WRITTEN REPRESENTATION ON BEHALF OF NORFOLK WILDLIFE TRUST

Application by East Pye Solar Limited for the East Pye Solar Development Consent Order

Planning Inspectorate Reference: EN0110014

Figure 8.3 Non-Statutory Designated Sites within 2km
 Index Sheet
 Revision A

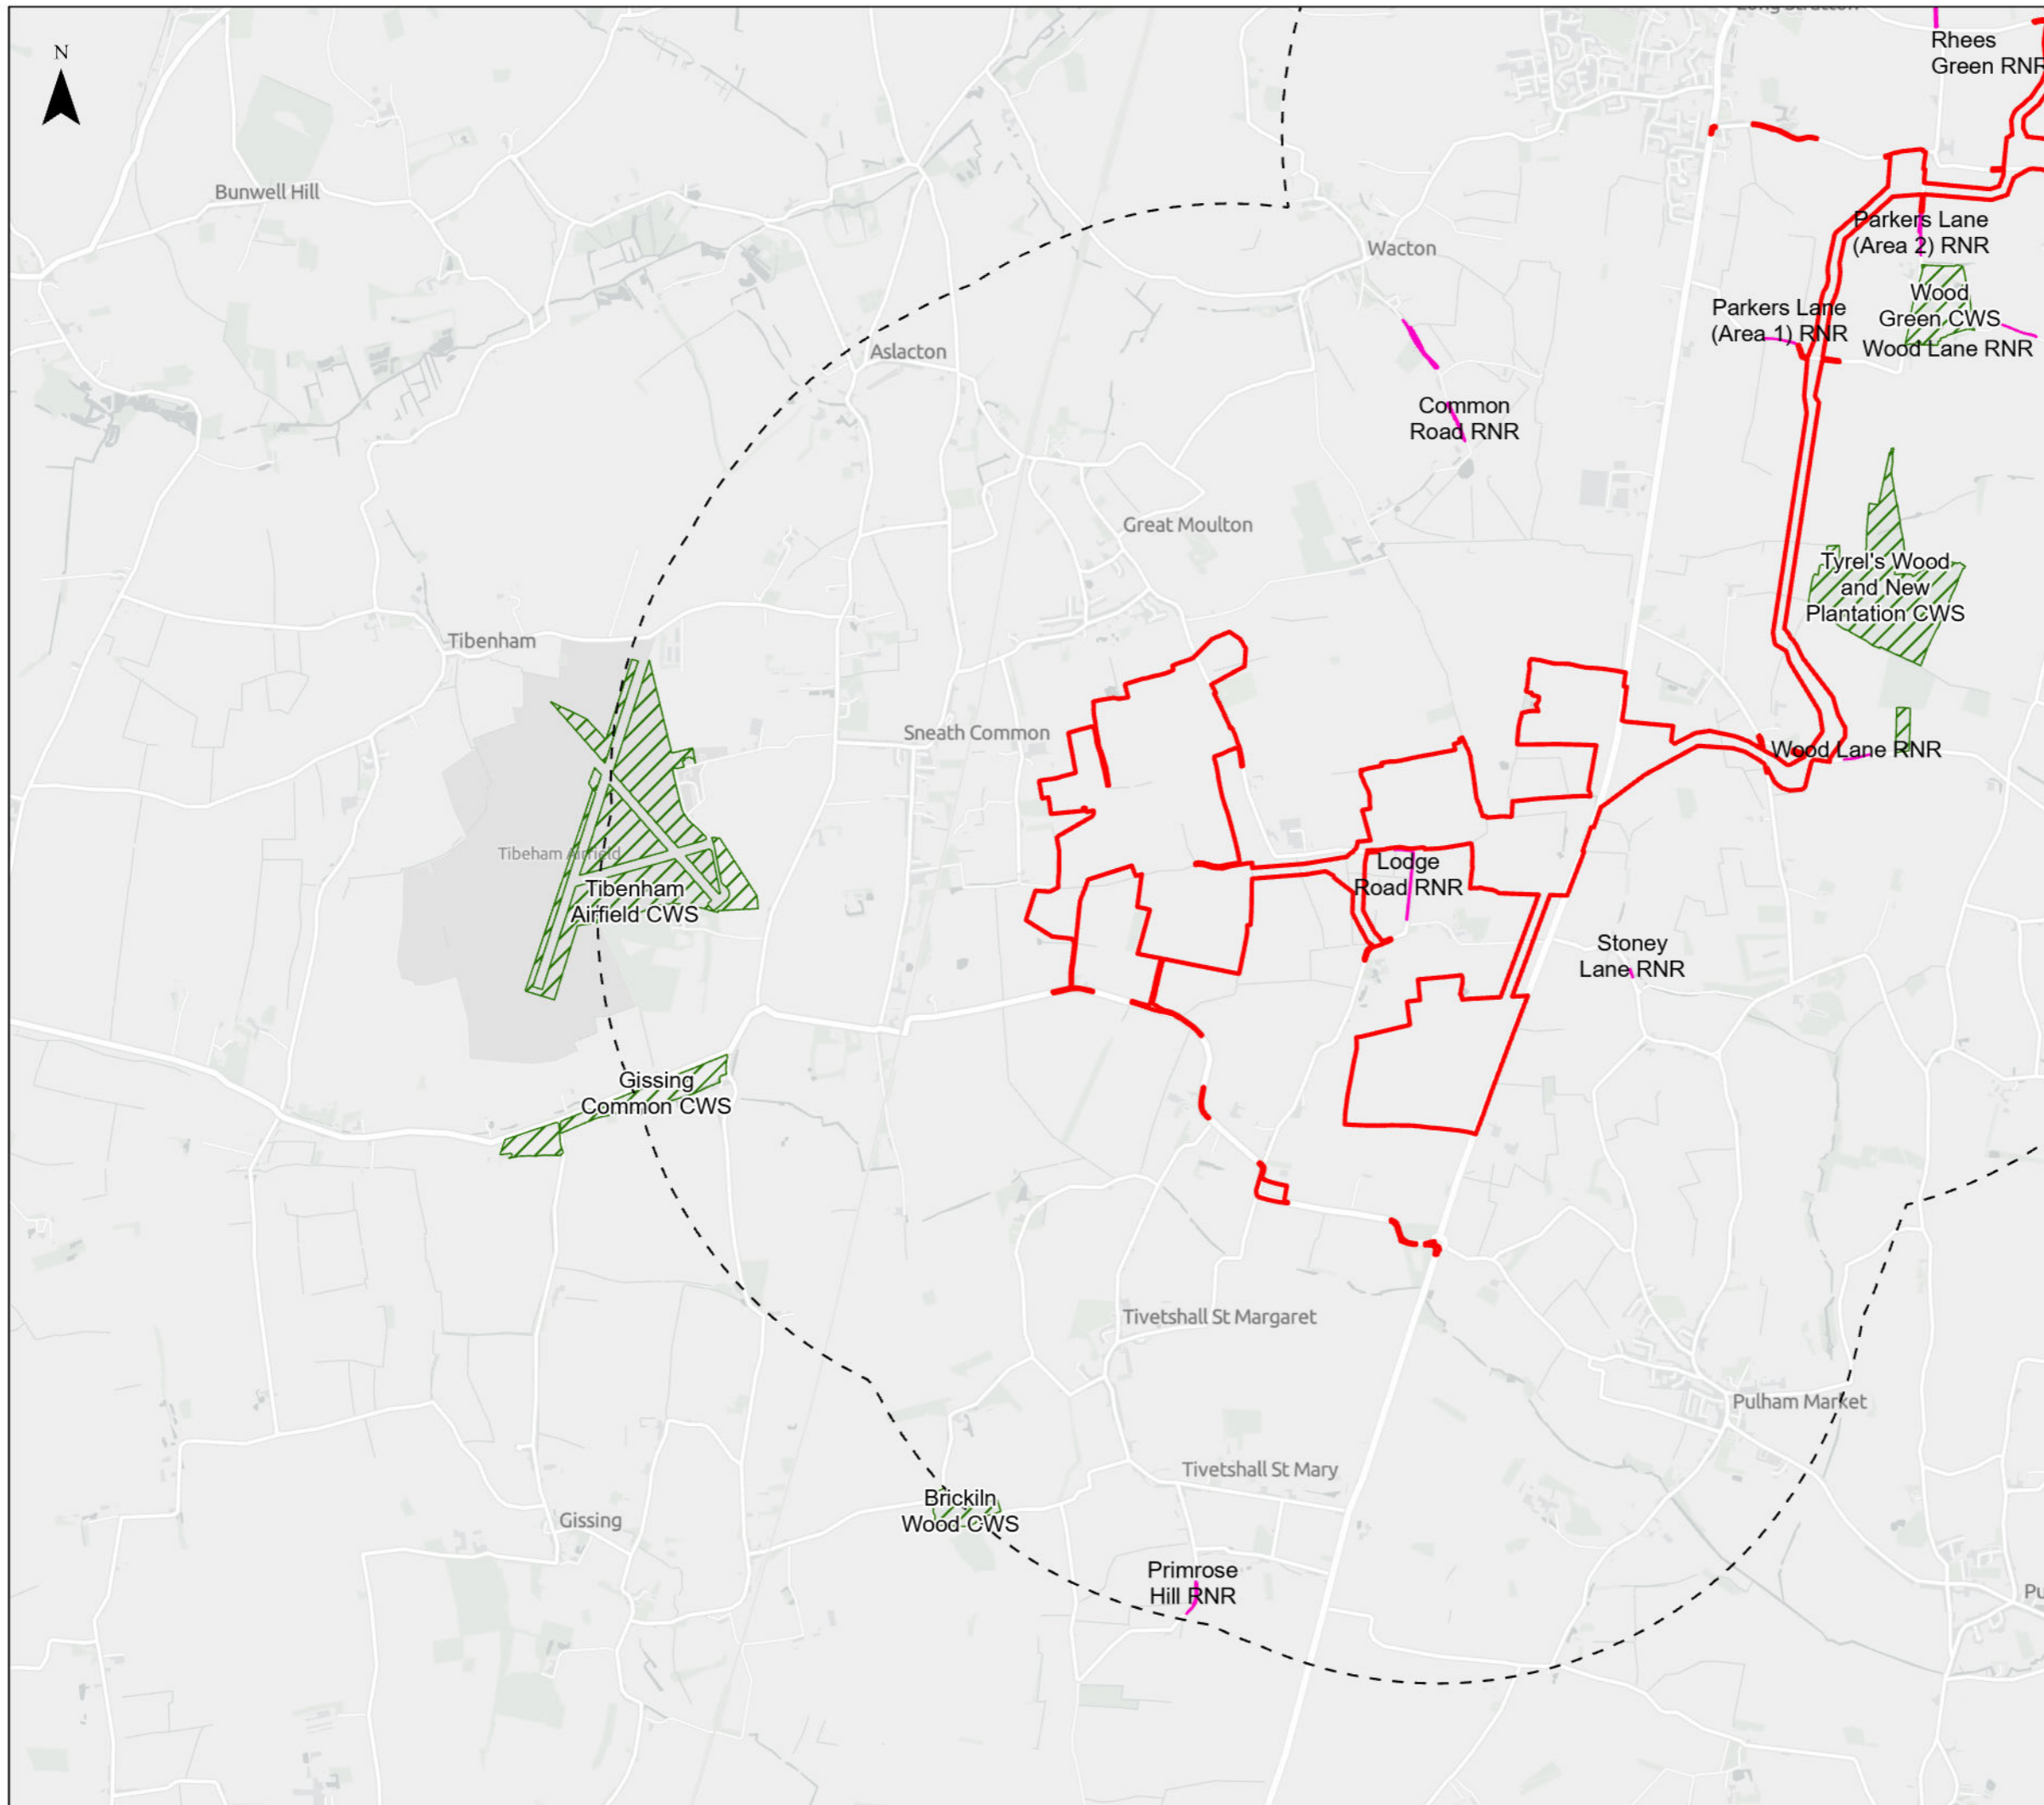
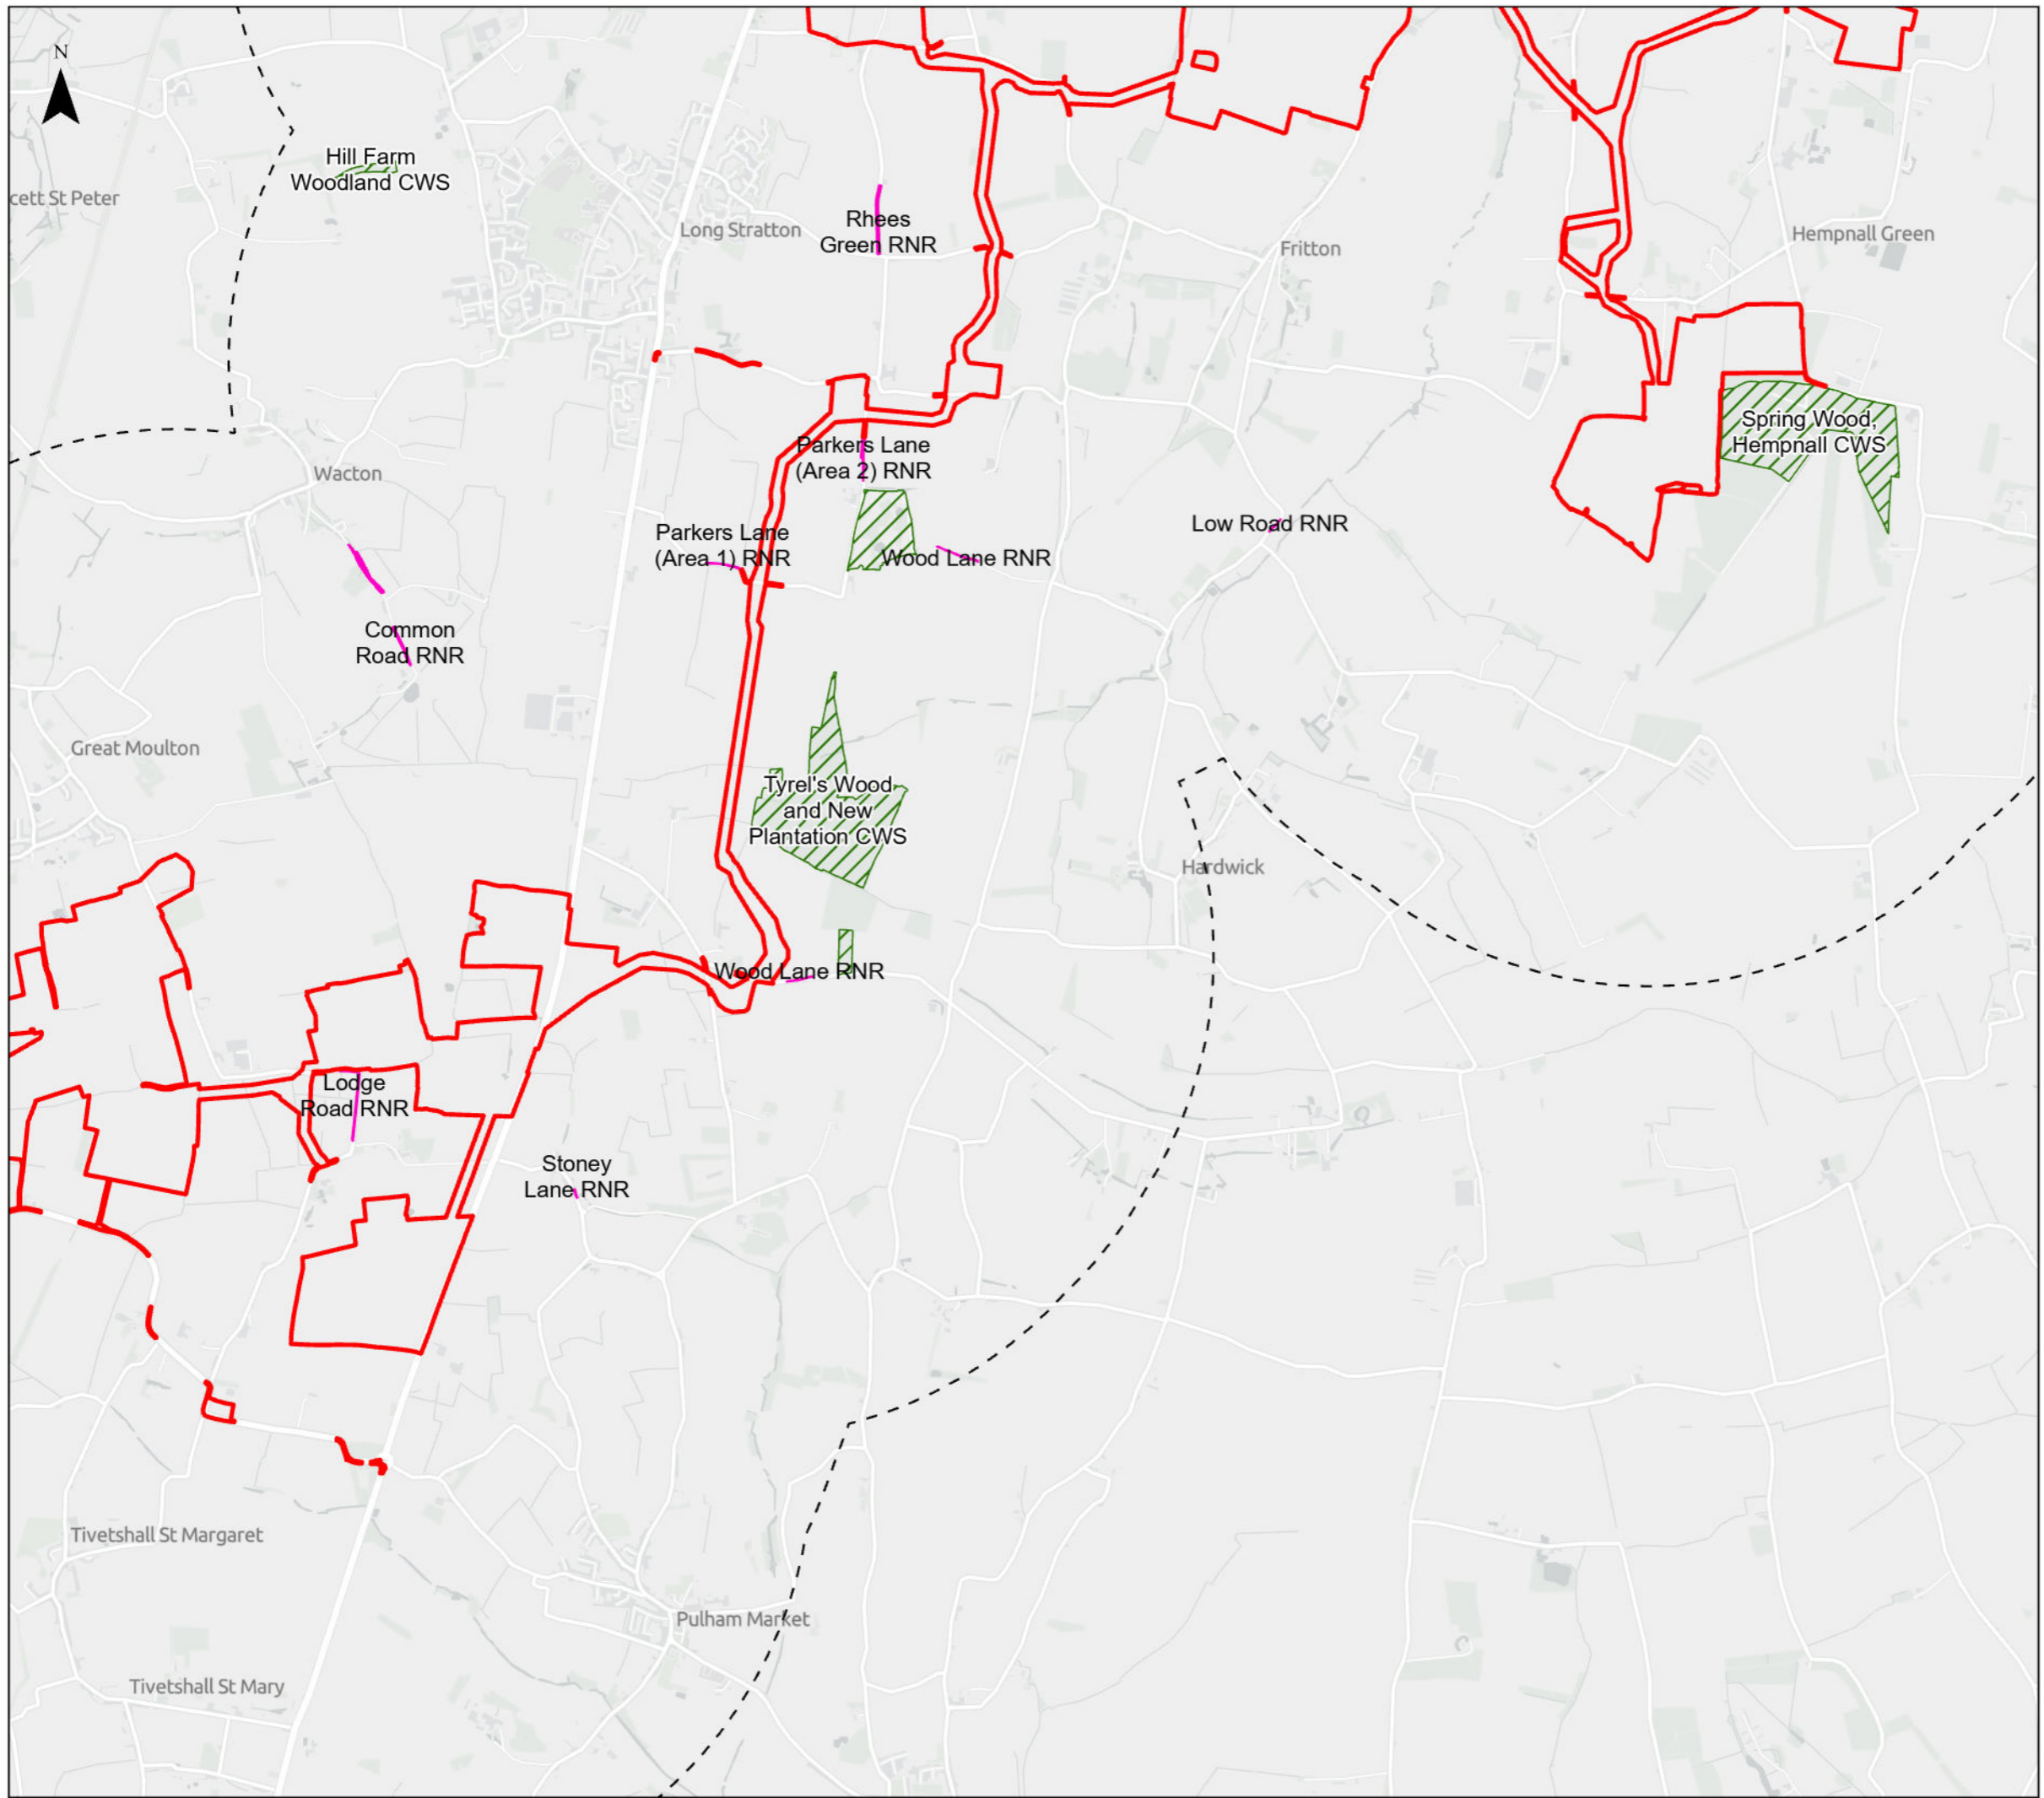
County Wildlife Sites represent an essential component of Norfolk's ecological network and often provide important habitat for priority species outside nationally designated sites. As outlined in paragraph 8.6.7 (ES Chap 8), the Order Limits include parts of two CWSs; Lower Spring Wood CWS (within CR9), and Fritton

Grange Meadows CWS (within CR7), and are adjacent/in the immediate vicinity of several others. The Order Limits also include or adjoin several Roadside Nature Reserves (RNRs), including Bussey's Loke RNR (Sub-Site 7G), Market Lane RNR (Sub-Site 8A), Parkers Lane RNR (Area 1) (CRC4), and Parkers Lane RNR (Area 2) (CRC4). Both direct and indirect impacts on wildlife sites and associated habitat networks must be avoided.
